Comment Response Memo

23 August 2023

Strand Residence Critical Area Review 2 – CAO23-011

6950 Maker St

WEST SHORING WALL PROFILE
STA. -0+10.00 TO STA. 1+30.00
1" = 10.00' HORIZ.
1" = 5.00' VERT.

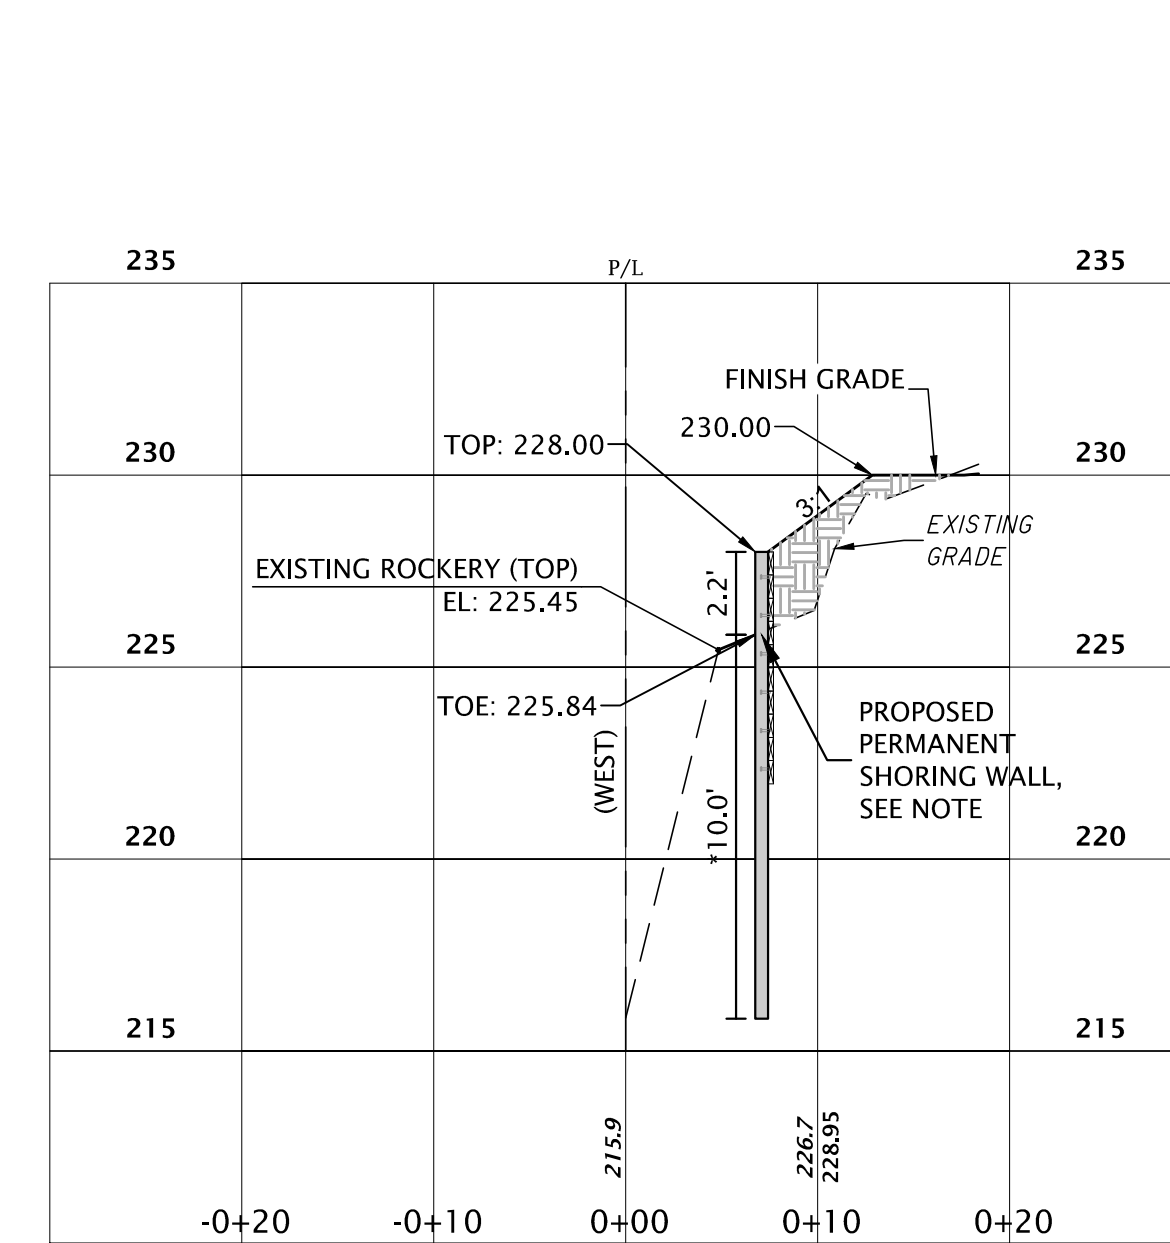
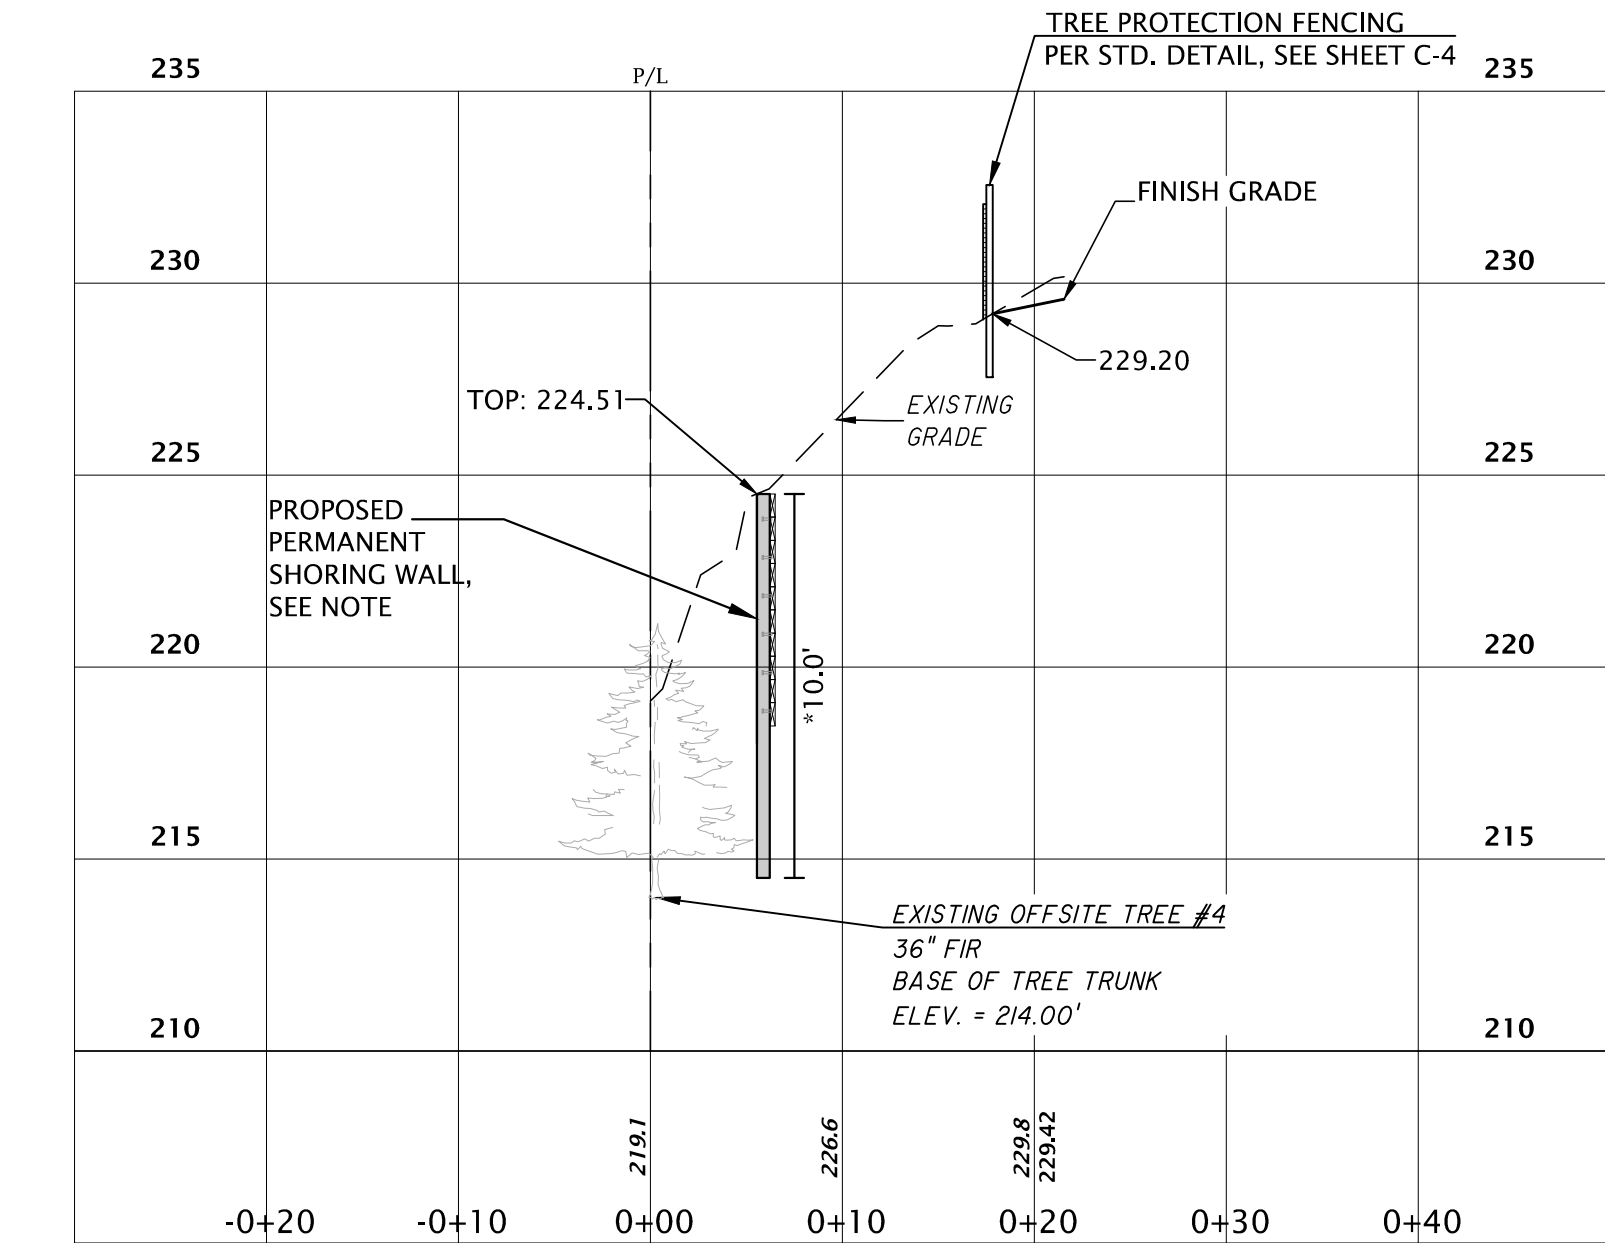
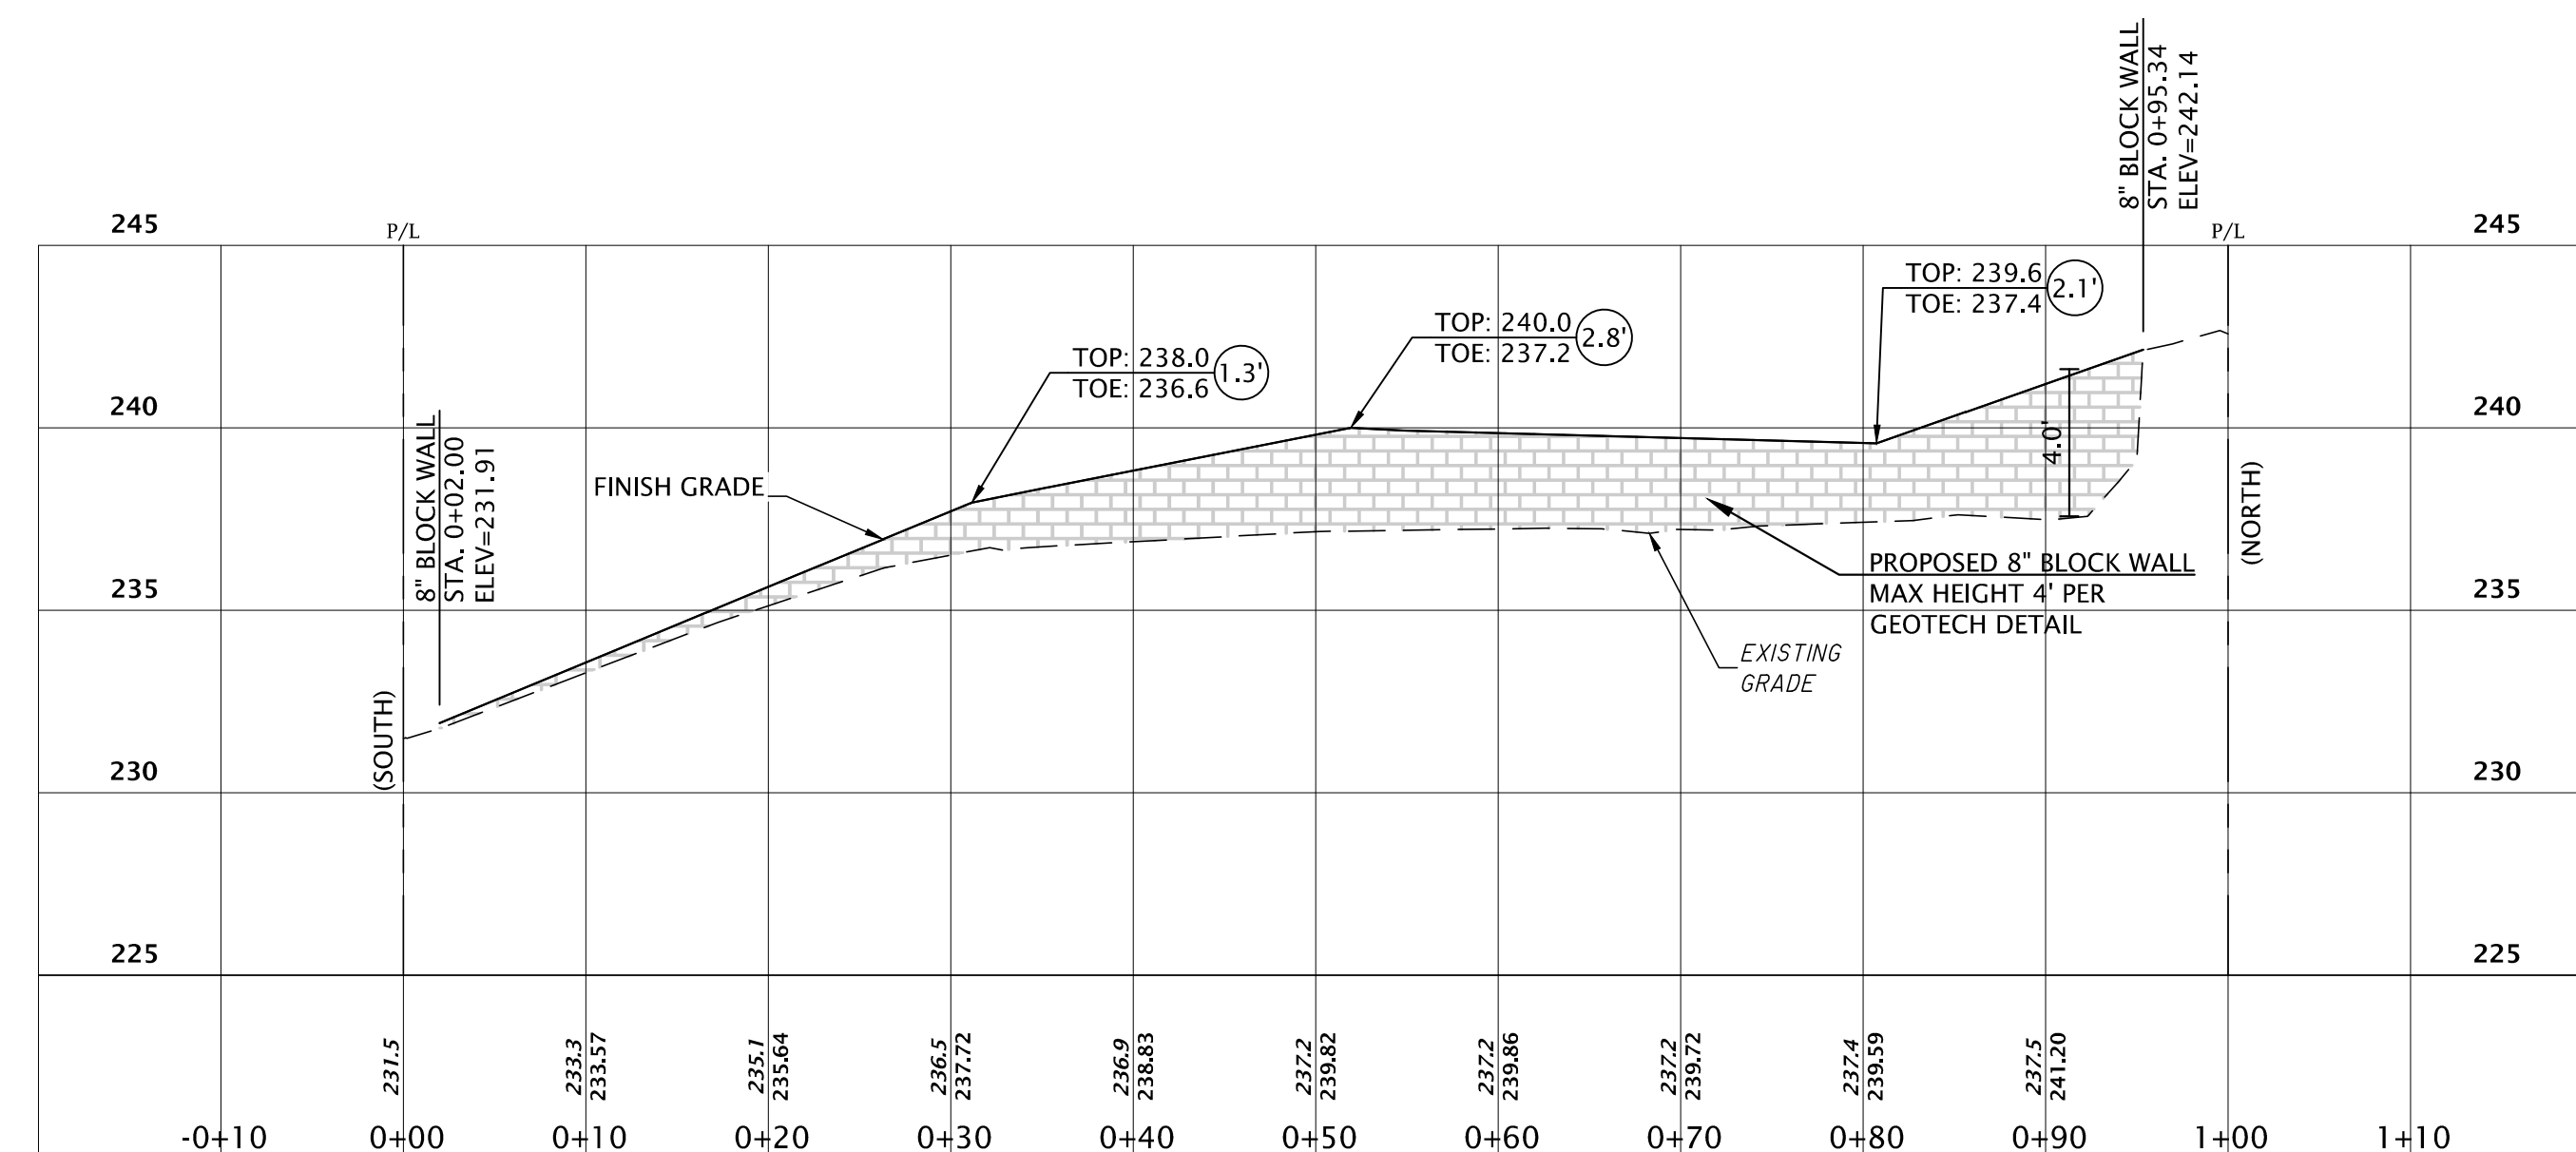
2. Regarding the letter from Jim and Susan Mattison -
I – The proposed West Shoring shall not increase the height of the finished grade by more than 72" from the existing grade elevation at any location. The shoring is solely intend to stabilize the existing conditions.
II – The impacts of the Shoring on Exceptional tree #4 have been reviewed and responded to by a certified arborist. The full response from the arborist is included in this submittal.
III – Any work associated with Exceptional tree #5 is not included in this permit and has been reviewed by the city arborist as part of other permits.
